**Application for Planning Permission for Works or Extension to a Dwelling**

**Development:** Demolition of existing single storey side area. Construction of two storey side extension, single storey rear extension and single storey front porch extension. Fitting of external insulation with render finish. Alterations to existing fenestration.

**Location:** 15 Elm Grove Barnham PO22 0HJ

DRAWING TITLE
PROPOSED ELEVATIONS

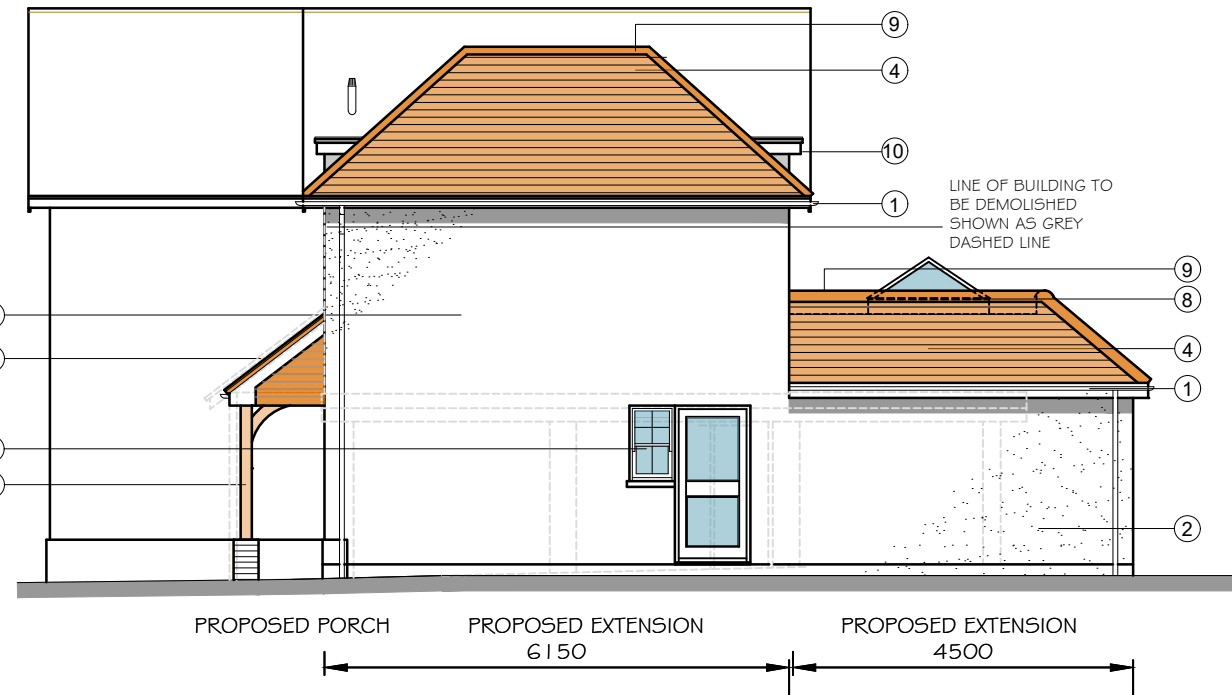
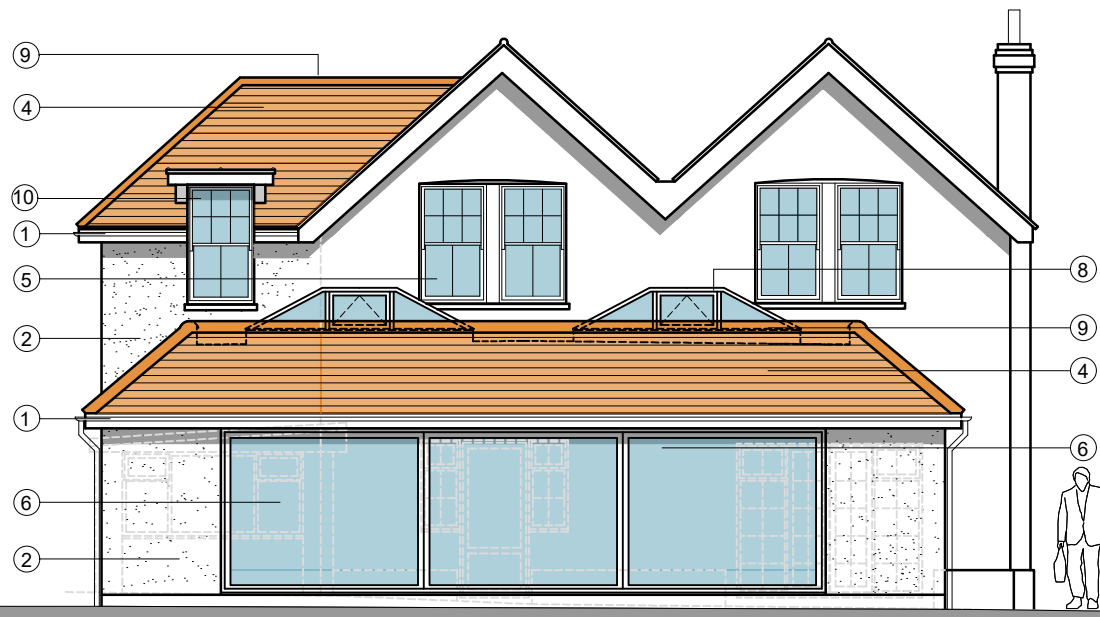
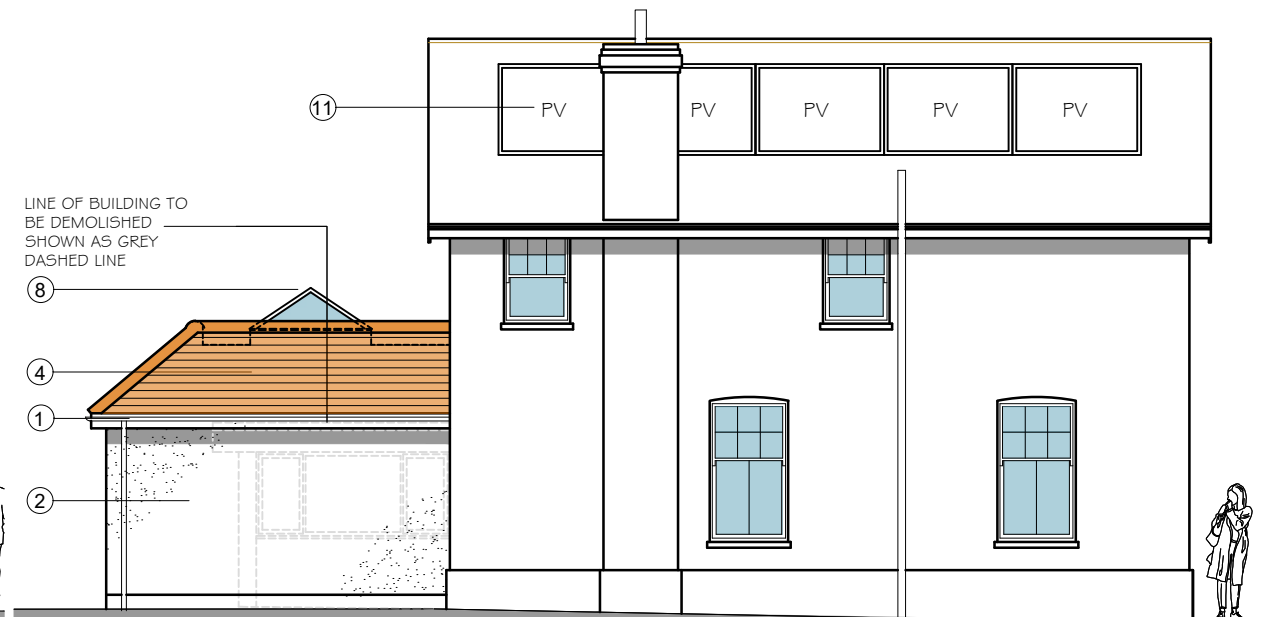
Please provide the manufacturer's specification for the proposed solar panels. Please add the proposed solar panels to the proposed description of works, or with your permission, we can add this for you.

DRAWING TITLE
 PROPOSED SITE PLAN
 (NEW SCHEME)

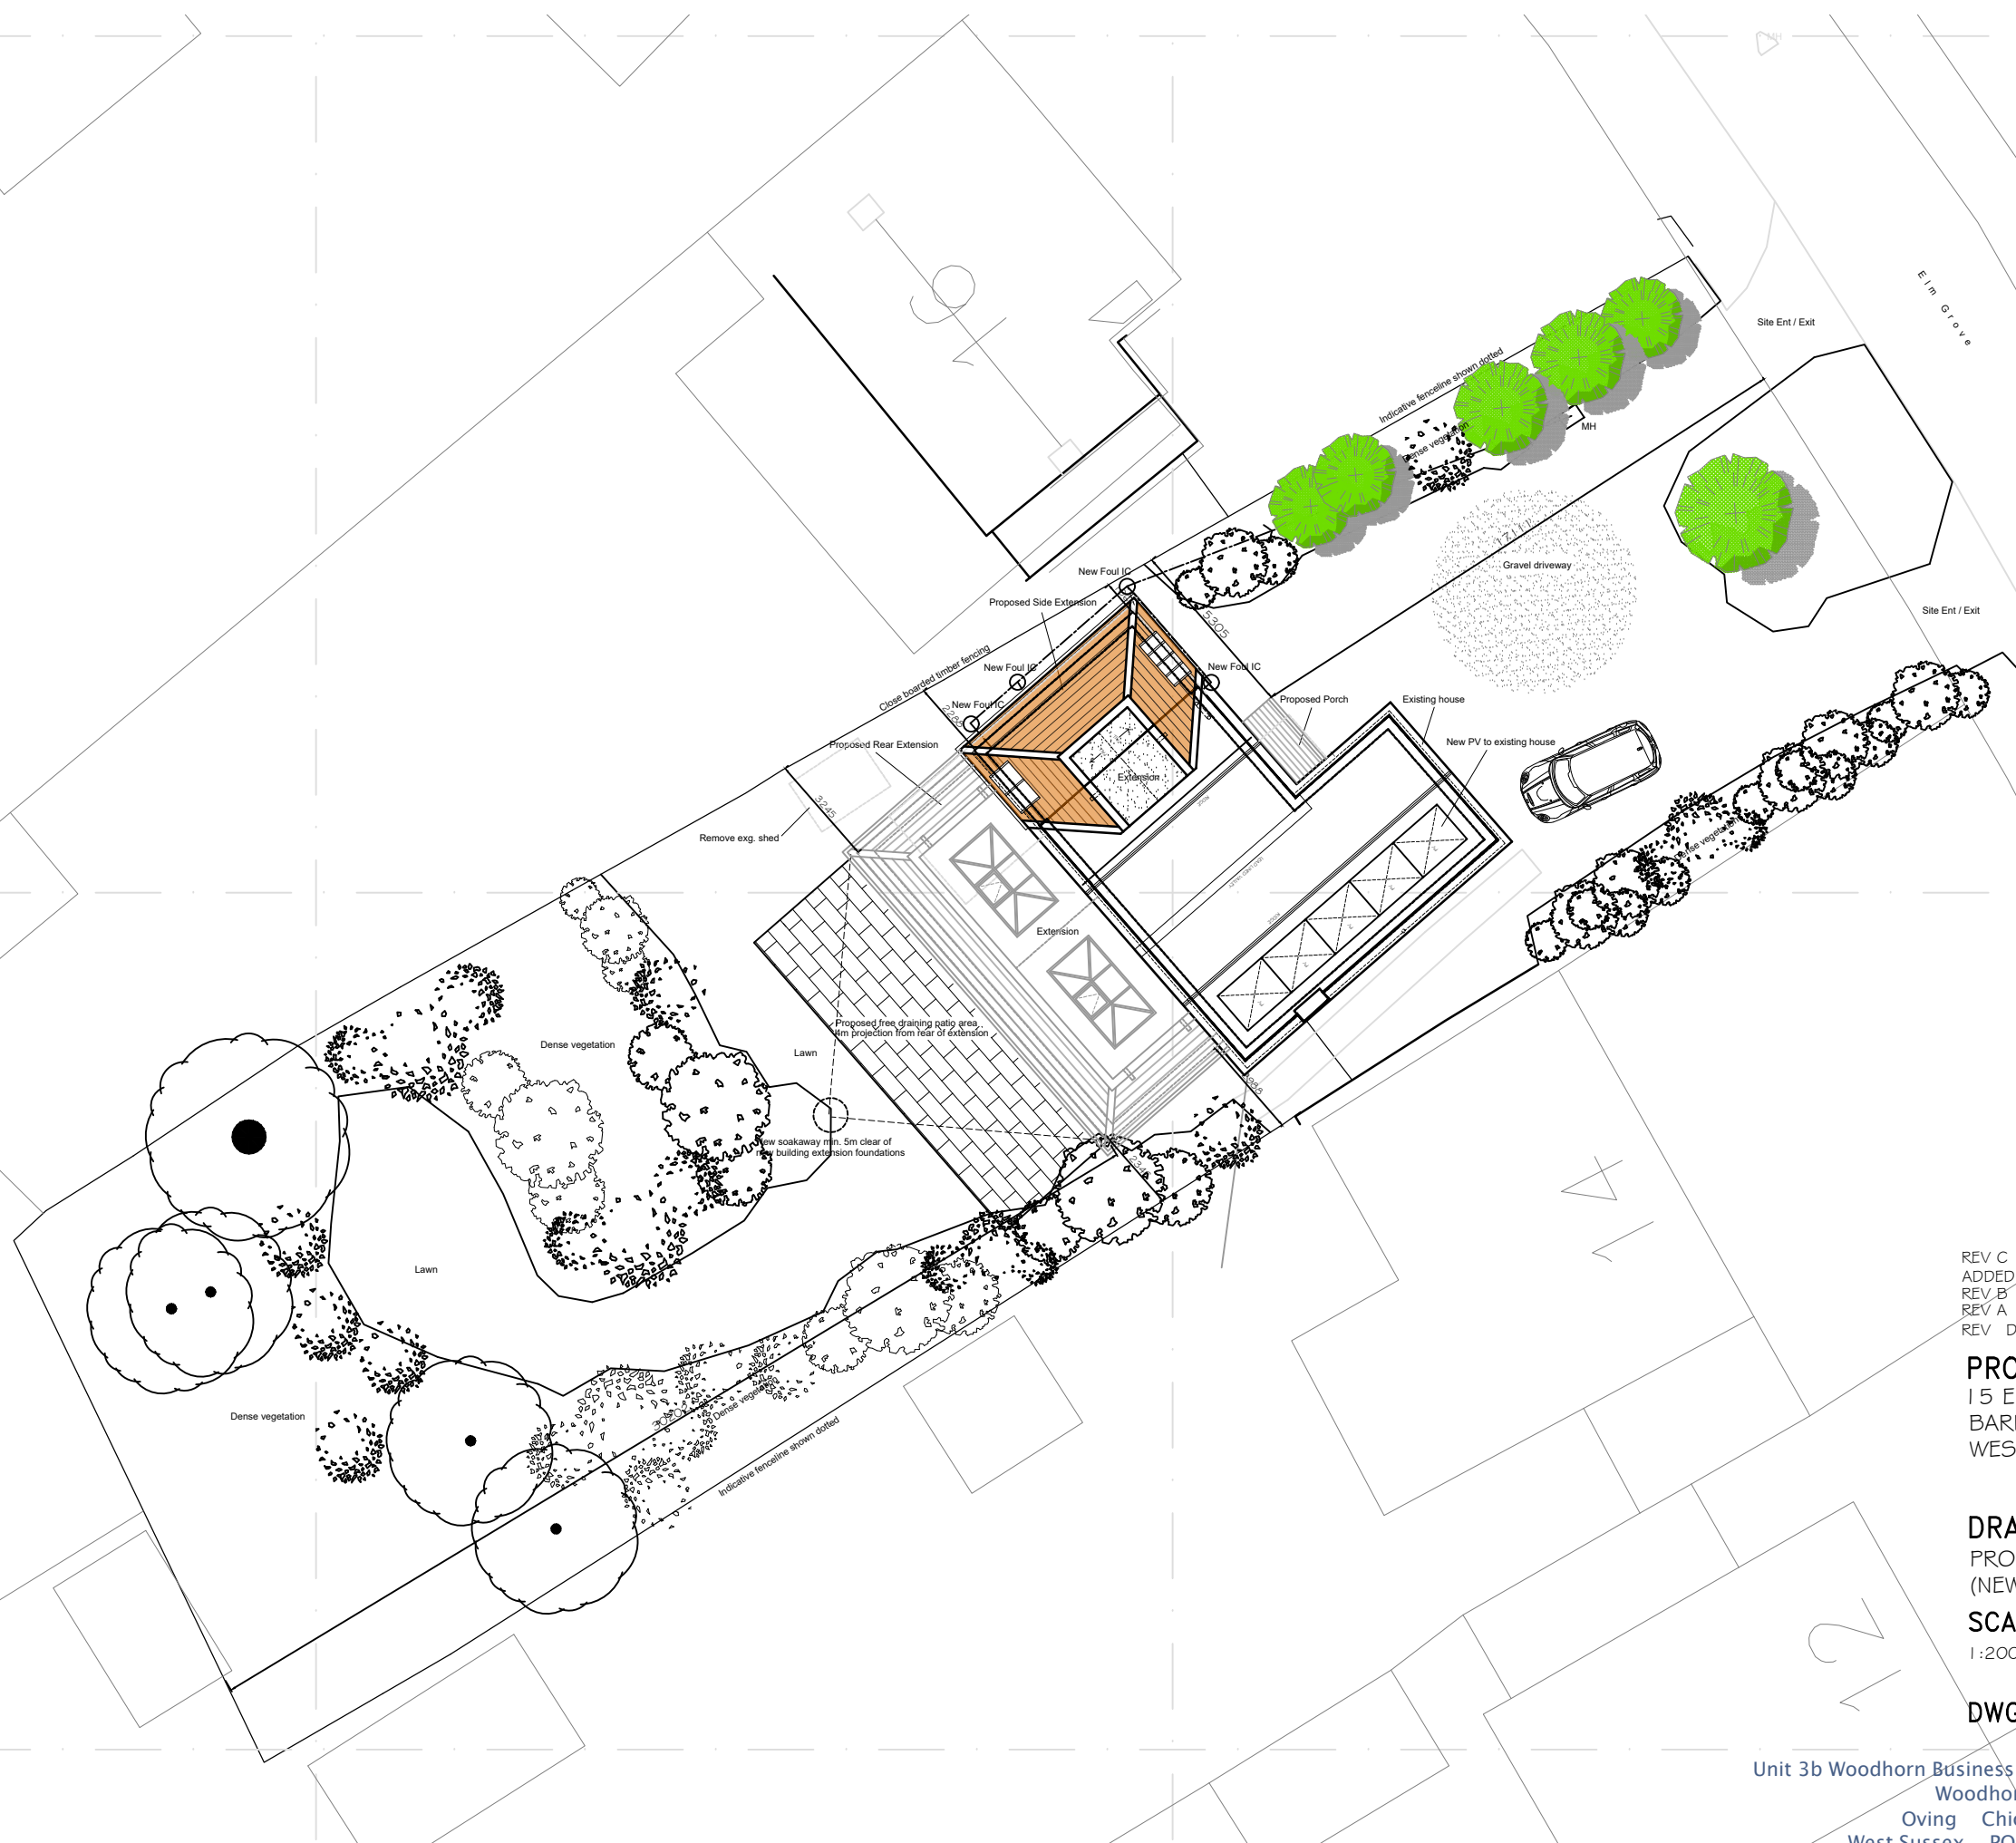
You are required to have dimensions from the proposed extension(s) to all site boundaries. Please amend
